CONSULTATION UNDER TOWN AND COUNTRY PLANNING ACT 1990

Application Number	PL/2023/00928/PPFL & PL/2023/00929/LBC
Address	Beeches Restaurant Marsh Lane, Hampton in Arden, Solihull.
Proposal	Retrospective consent for erection of a replacement extraction system
Case Officer	Ian Hiscock

Date comments sent	06 July 2023
Name of consultee department	CLAUDE Historic Environment
Consultation response author	Jon Beesley

1000

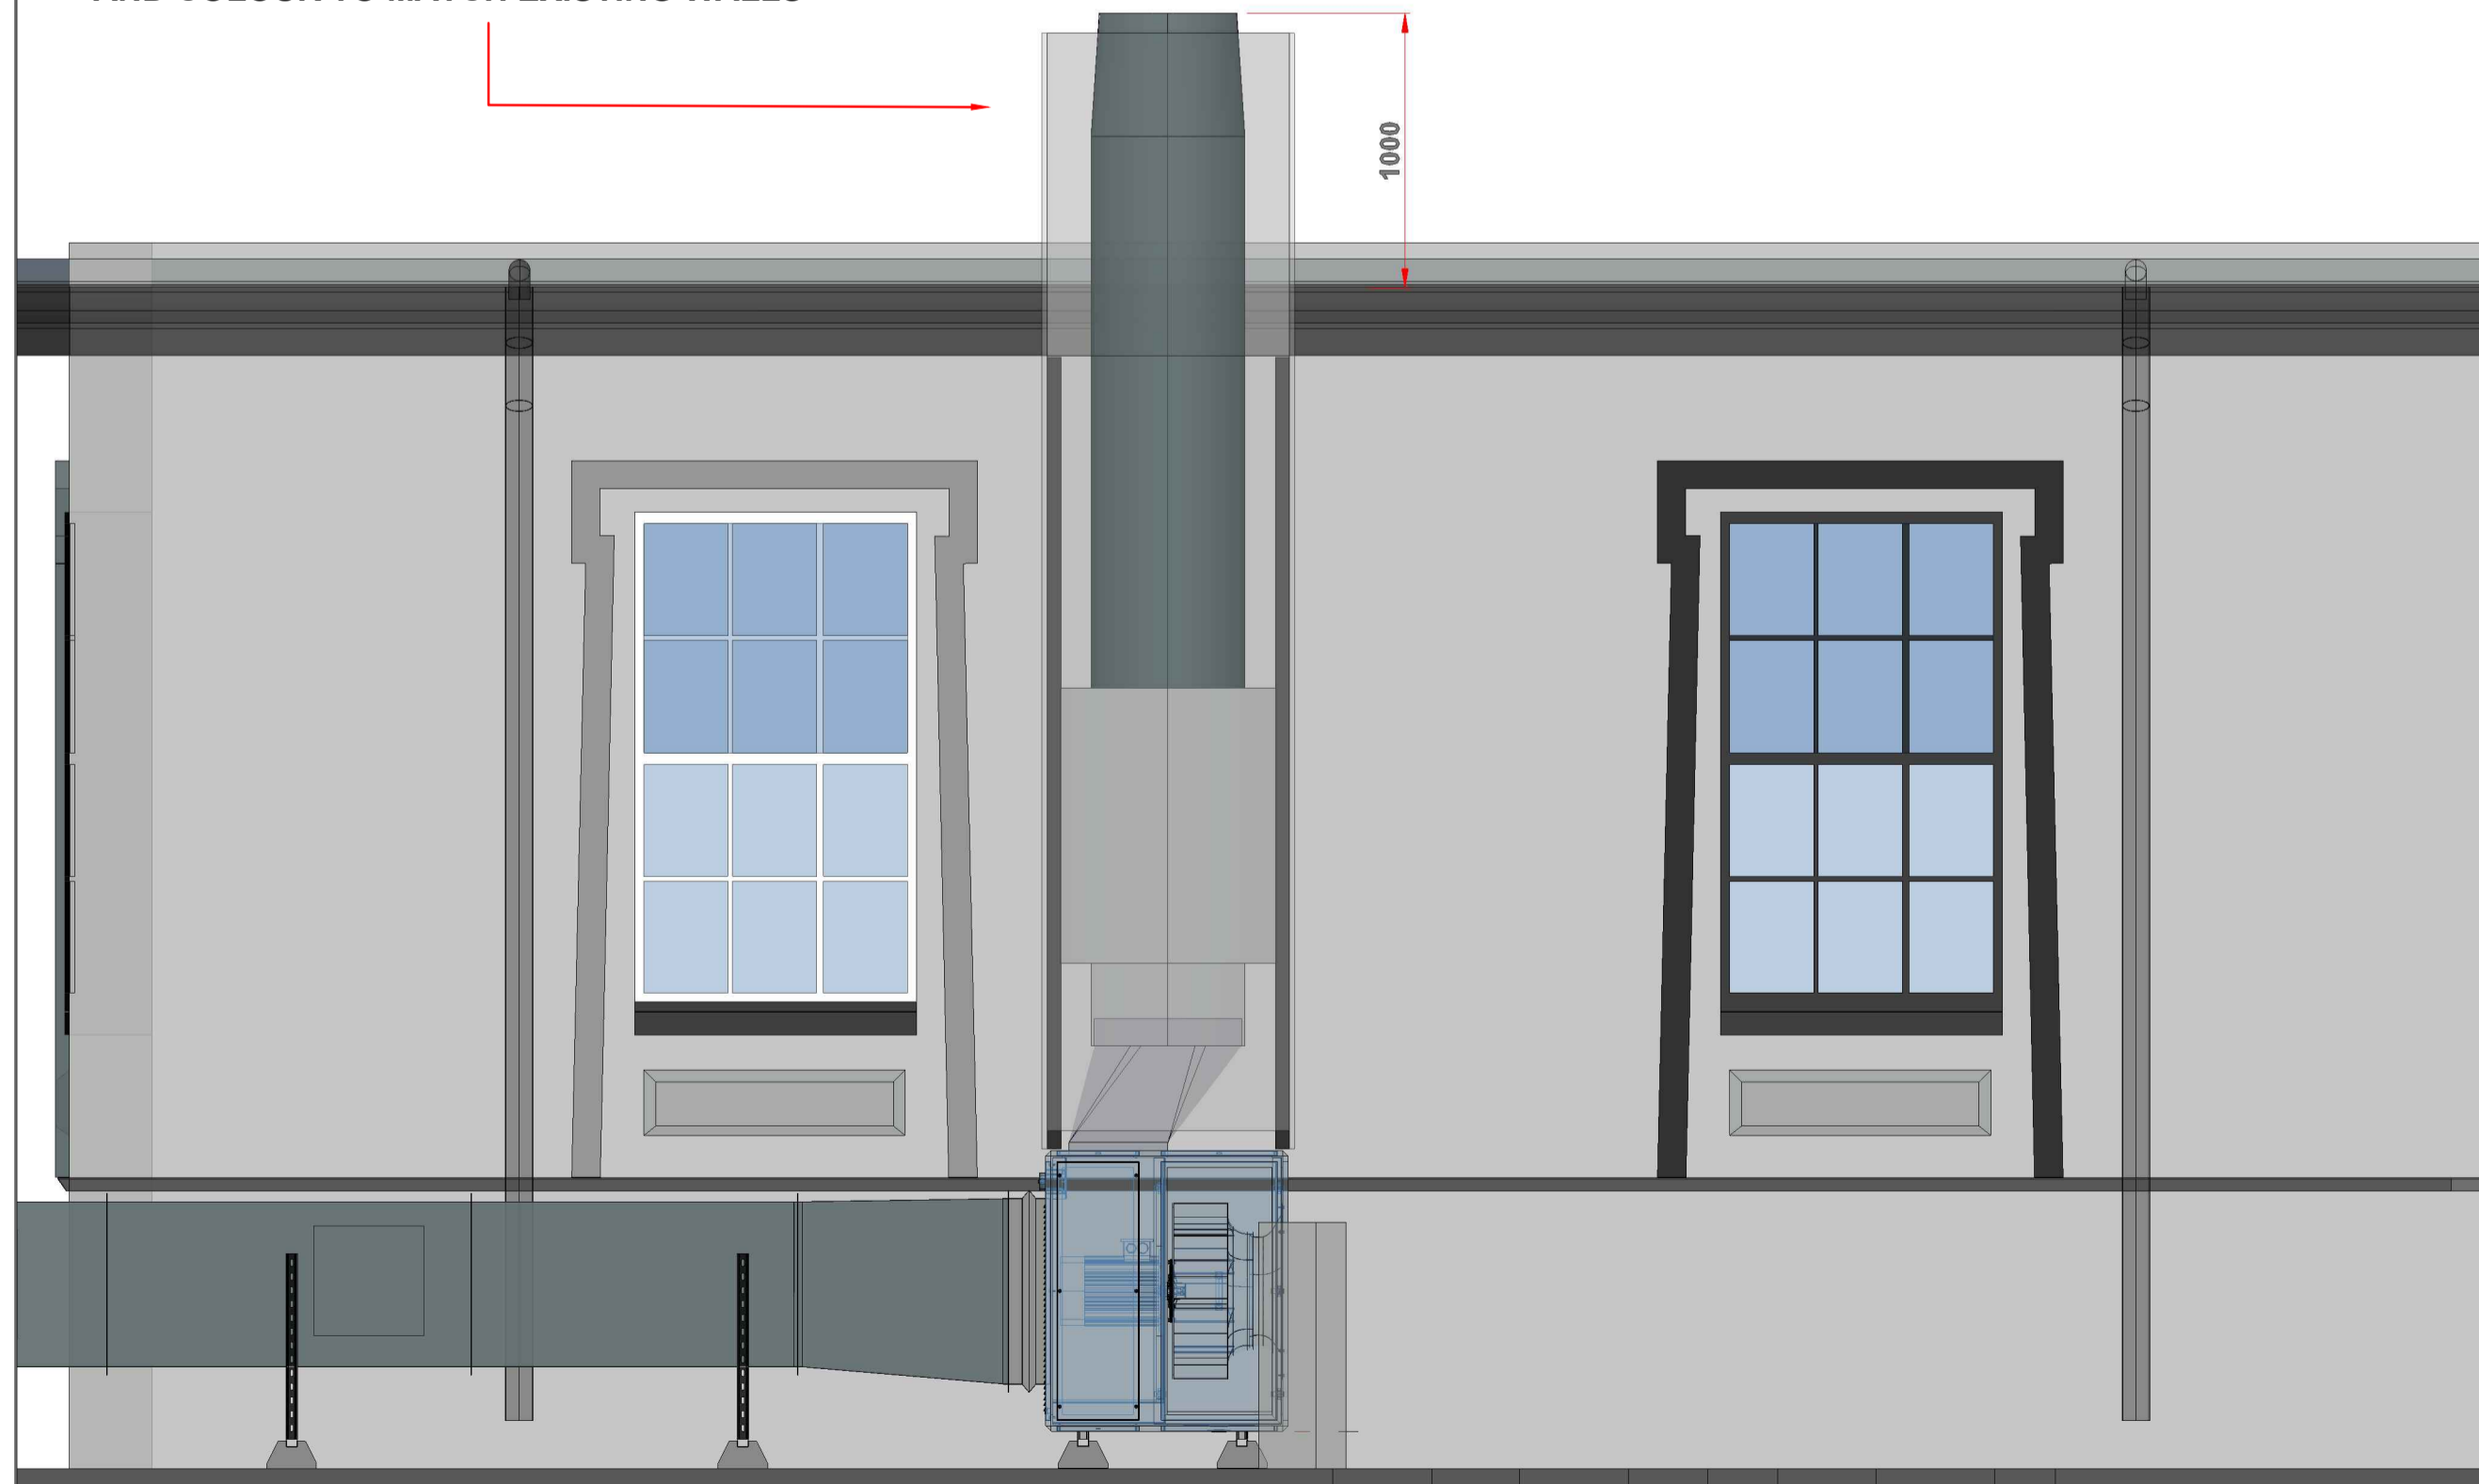
Concern was raised that the proposed cladding would partially obscure the window surround, which would harm the significance of the listed building. (*Ref: Heritage comments PL/2022/02174/PPFL & PL/2022/02175/LBC dated 9 Dec 2022.*) Further information on the installation was requested to allow an assessment of the potential impact on significance of the heritage assets. The issue has been addressed; and the proposed cladding should not obscure the window surround.
